Application for a Non-Material Amendment Following a Grant of Planning Permission

Proposed alterations and two storey extension on front elevation with dormer window.

21/00775/HOU

To carry the off-white render around to the rear of the new utility room, over the existing brickwork, with new Anthracite grey wood effect cladding above.

Drawing No.
252/PL15 Rev. C

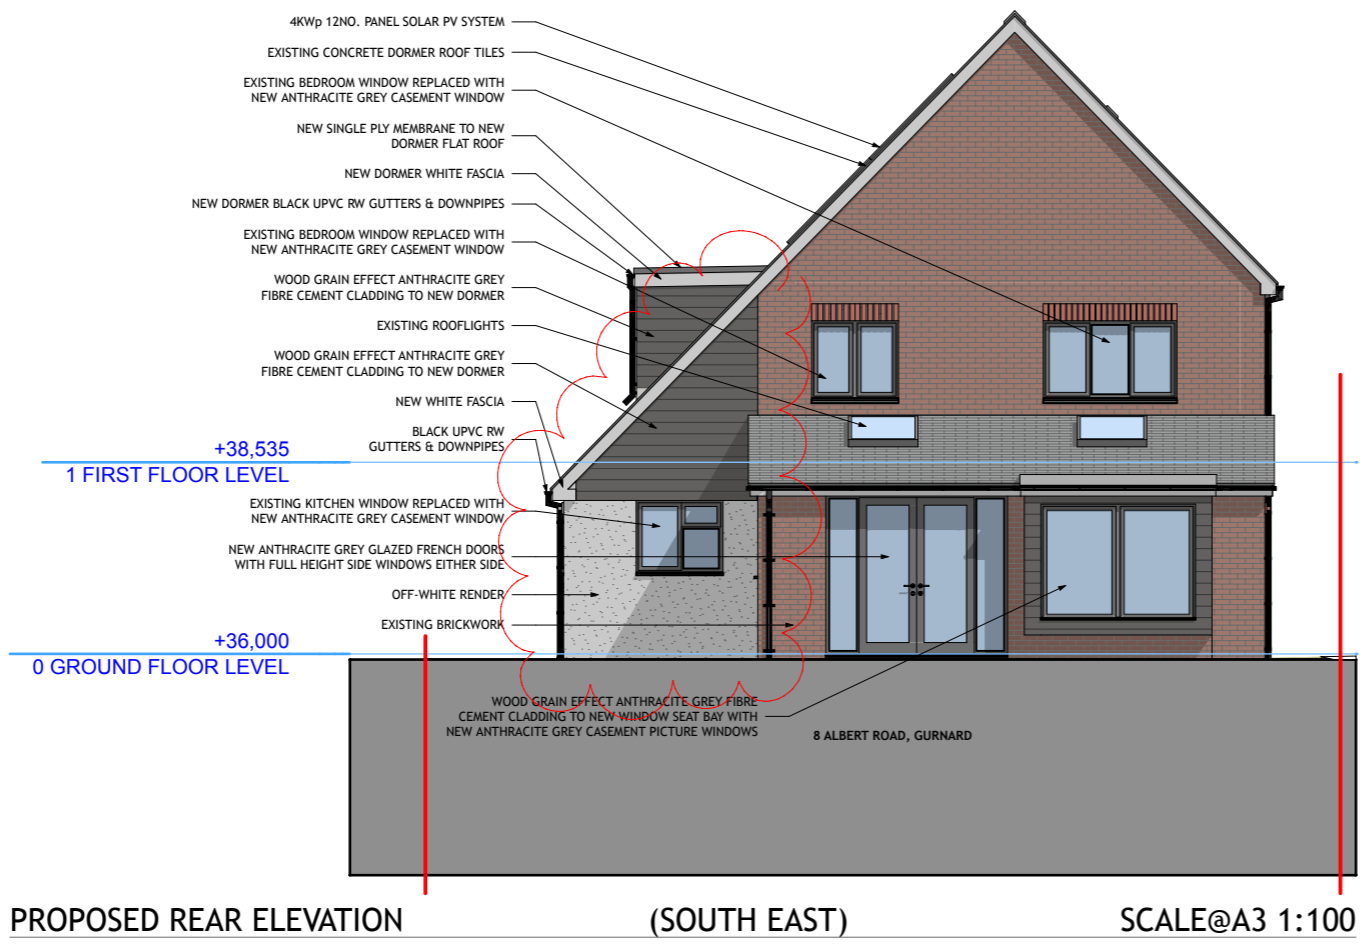
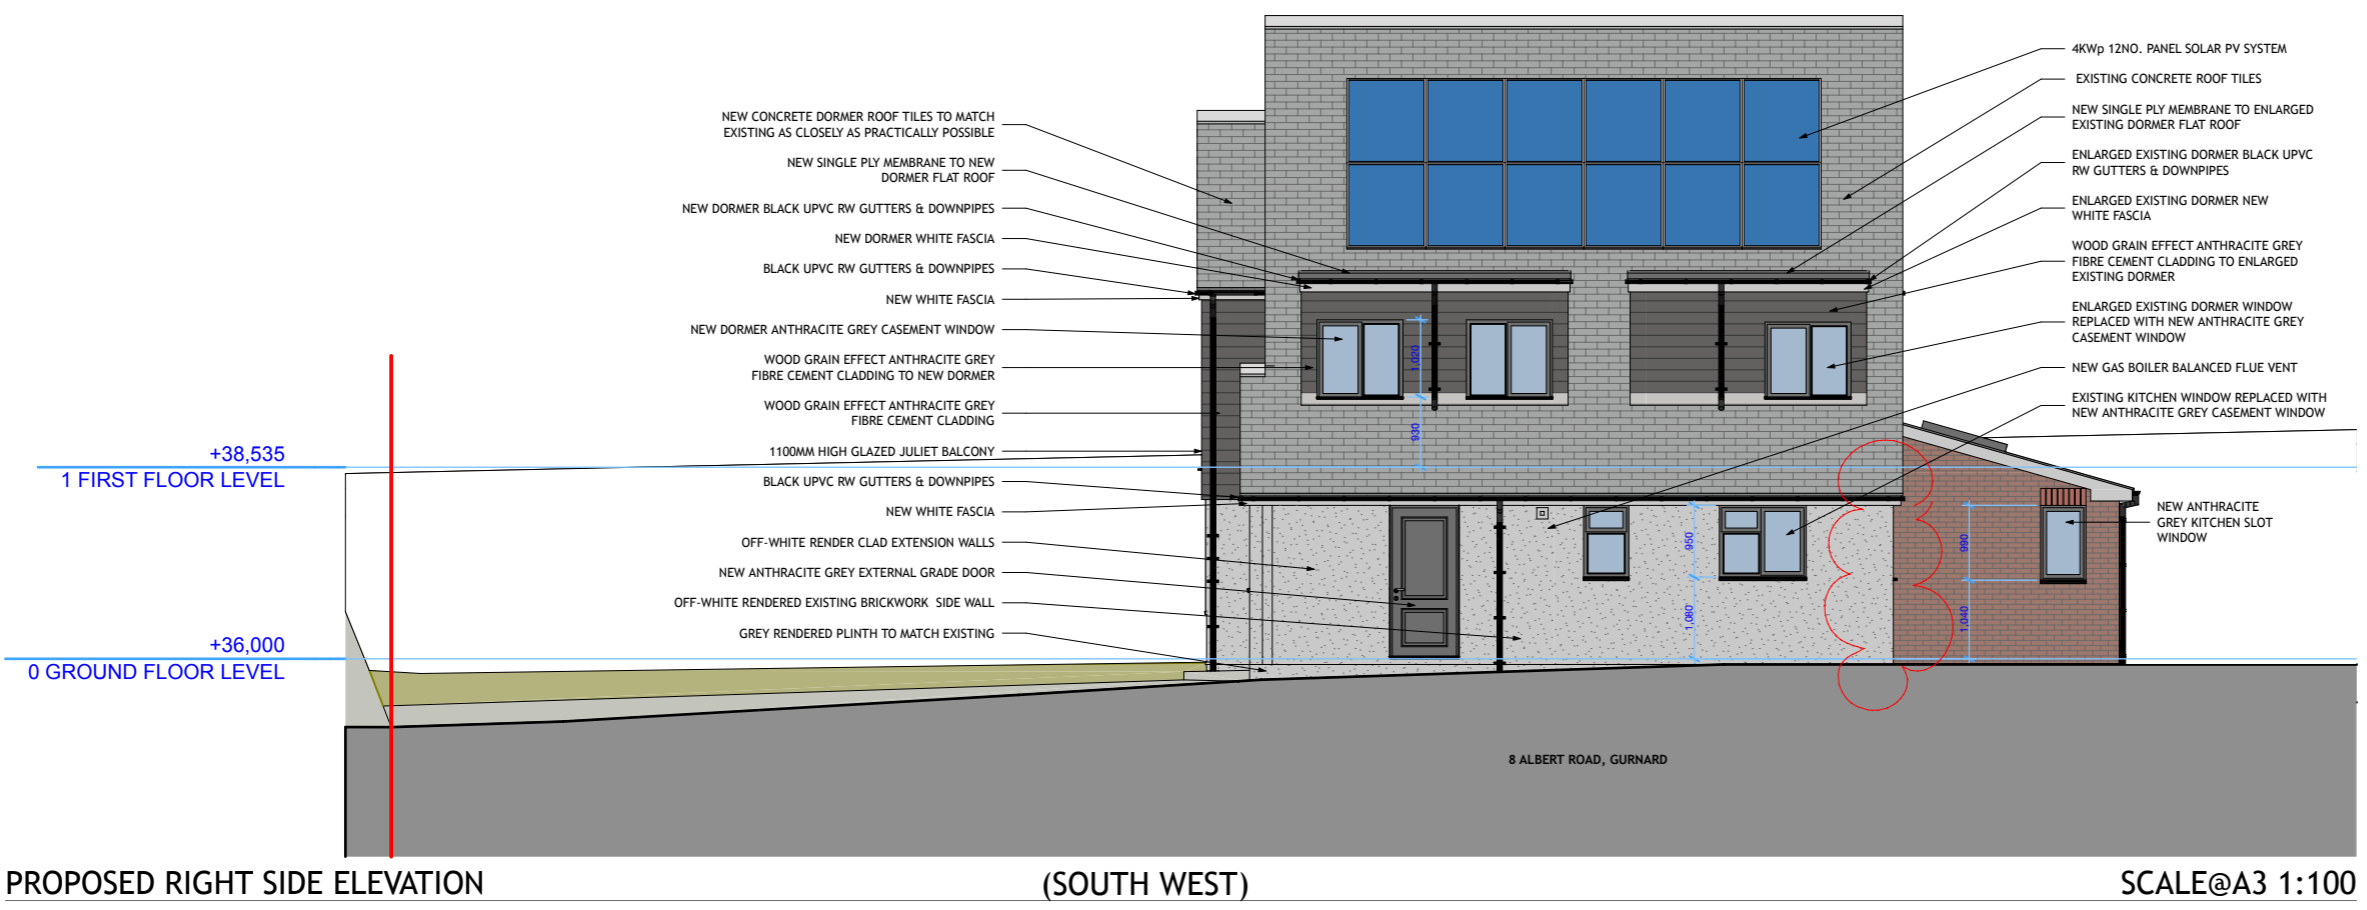
It will make a better finish to the rear elevation as the render and cladding will finish at an internal corner.
